WINDERMERE
EROSION CONTROL AND STORMWATER QUALITY PLAN
E 1/2 OF SECTION 29,
T13S, R65W OF THE 6TH P.M.
EL PASO COUNTY, COLORADO

Engineering Review
12/09/2020 2:45:43 PM
dsdricc
JeffRice@elpasoco.com
(719) 520-7877
EPC Planning & Community
Development Department

PCD-ENGINEERING REVIEW COMMENTS
IN BLUE BOXES WITH BLUE TEXT

**INITIAL/INTERIM
 EROSION CONTROL
 PLAN**

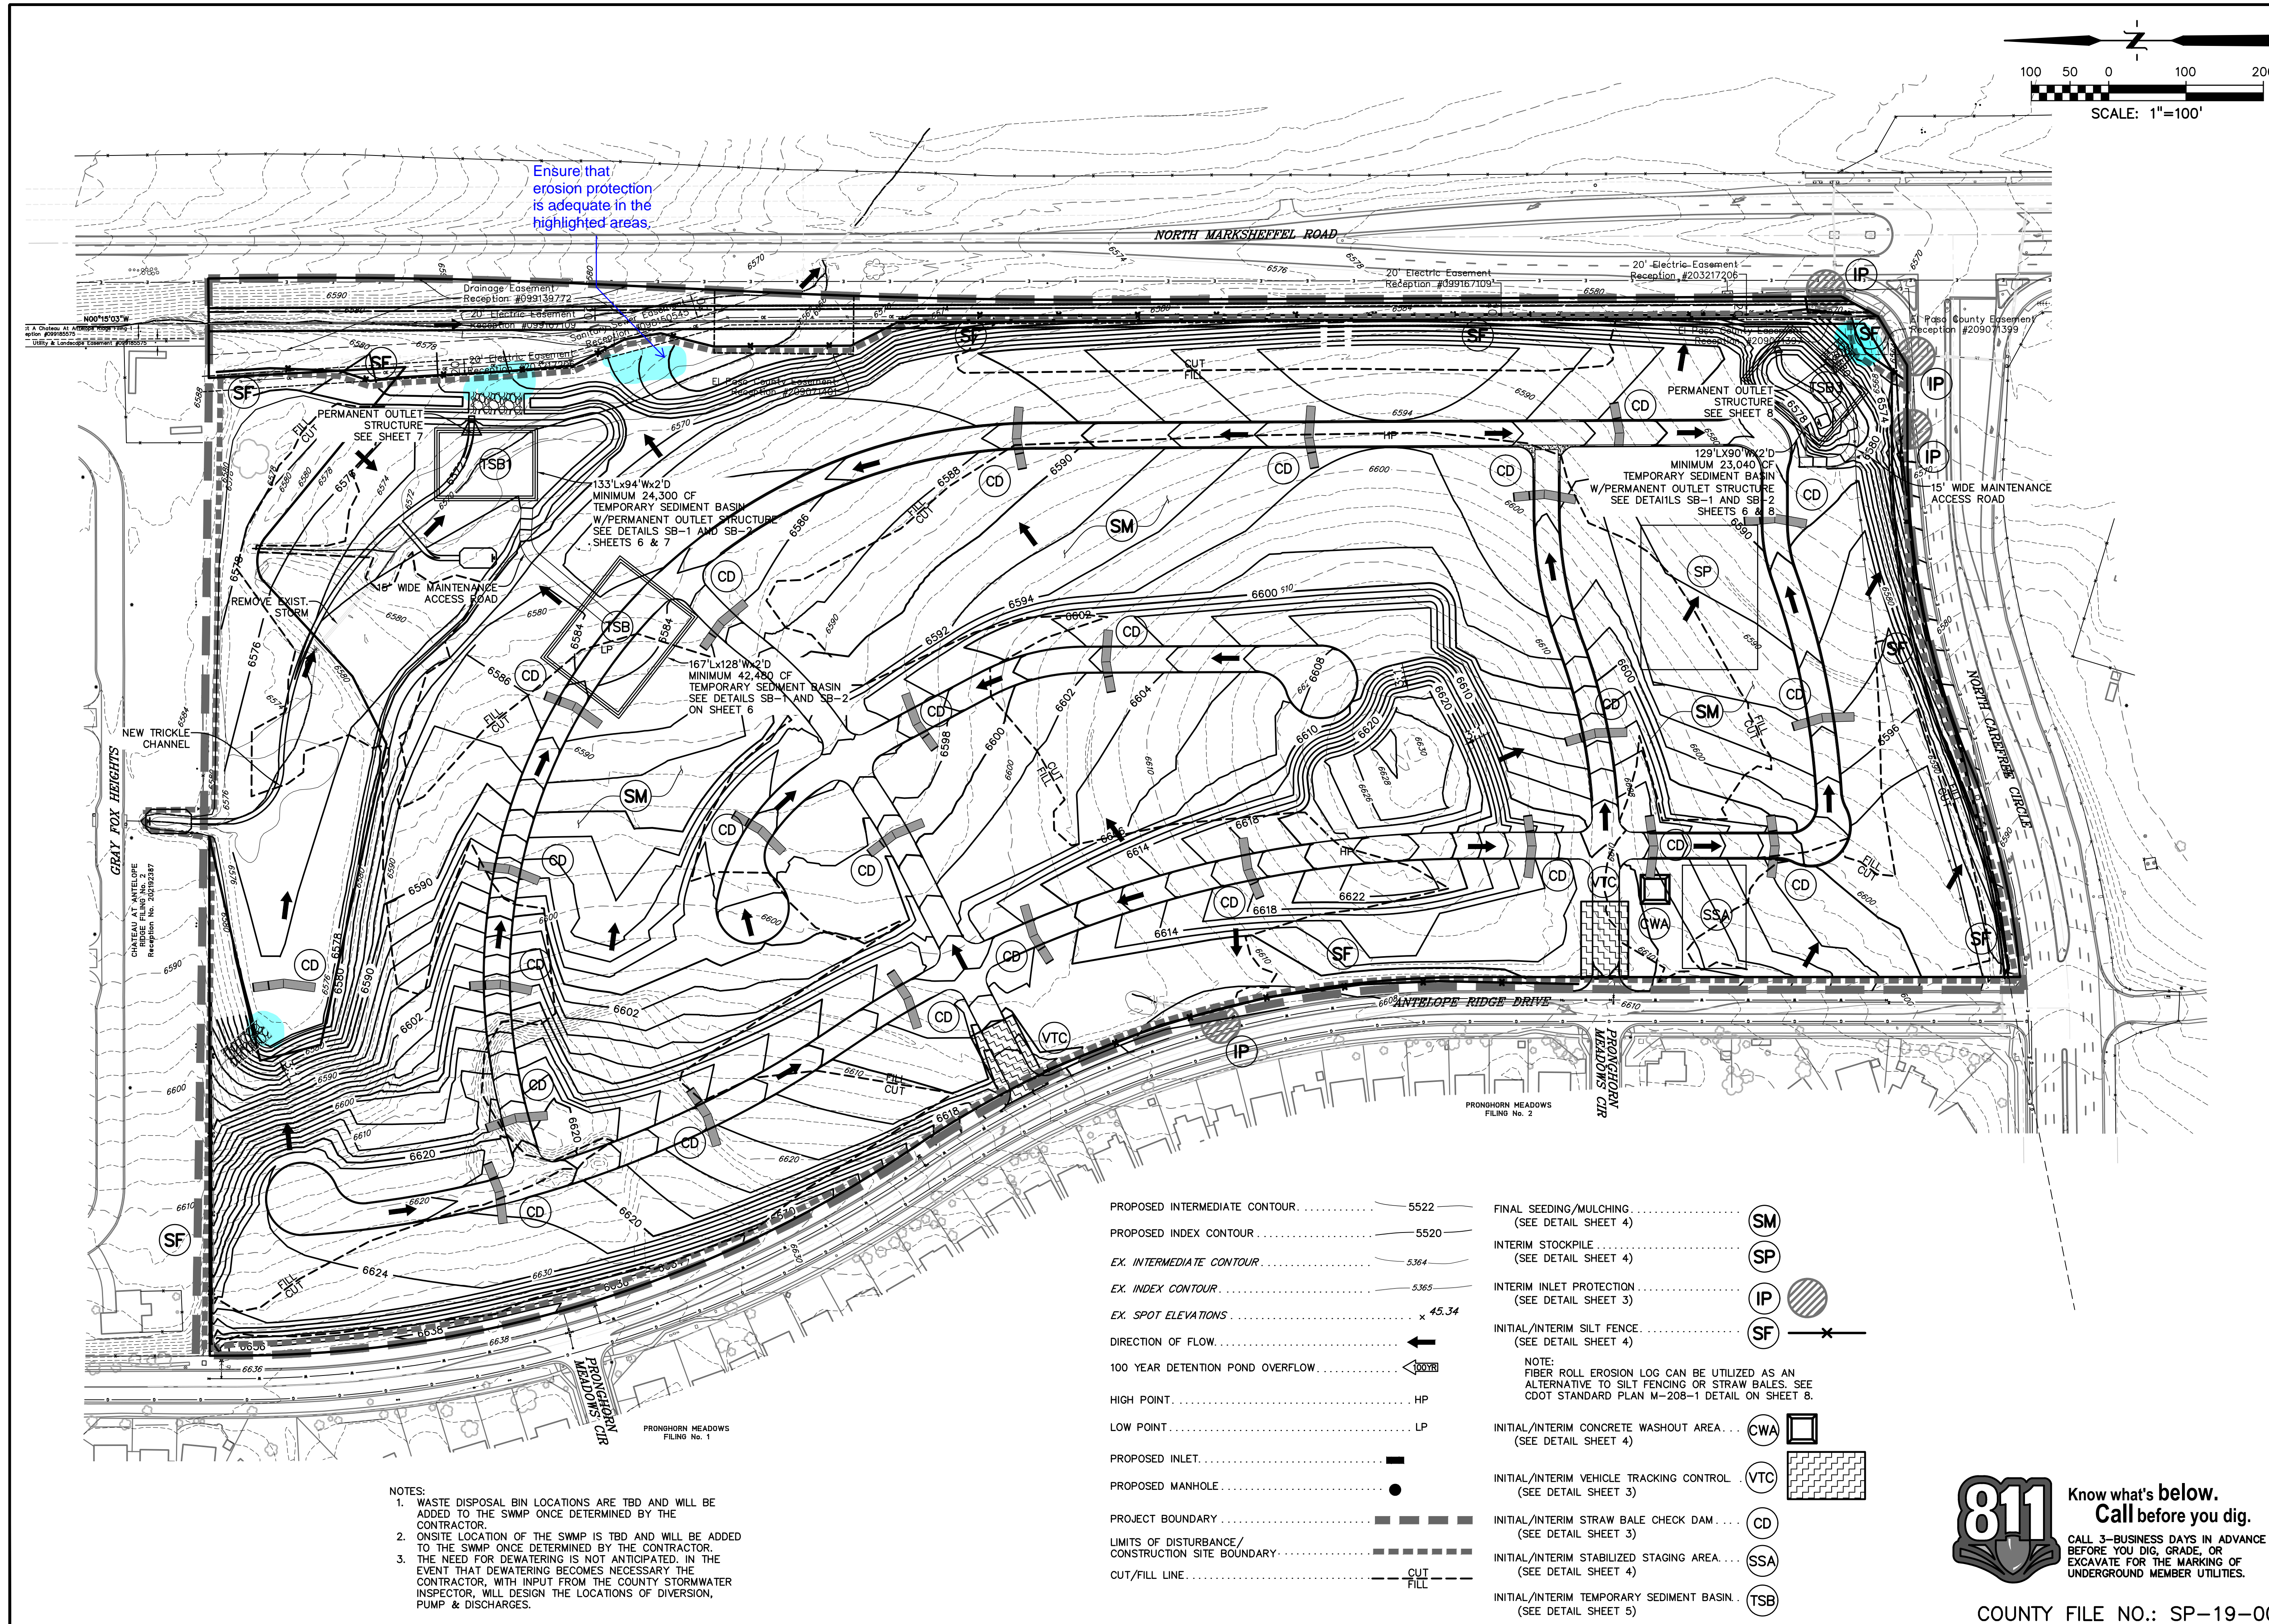
Complete construction plans and details are required for
the ponds if they are are being constructed with the EGP.

fill in with preparer and date of report
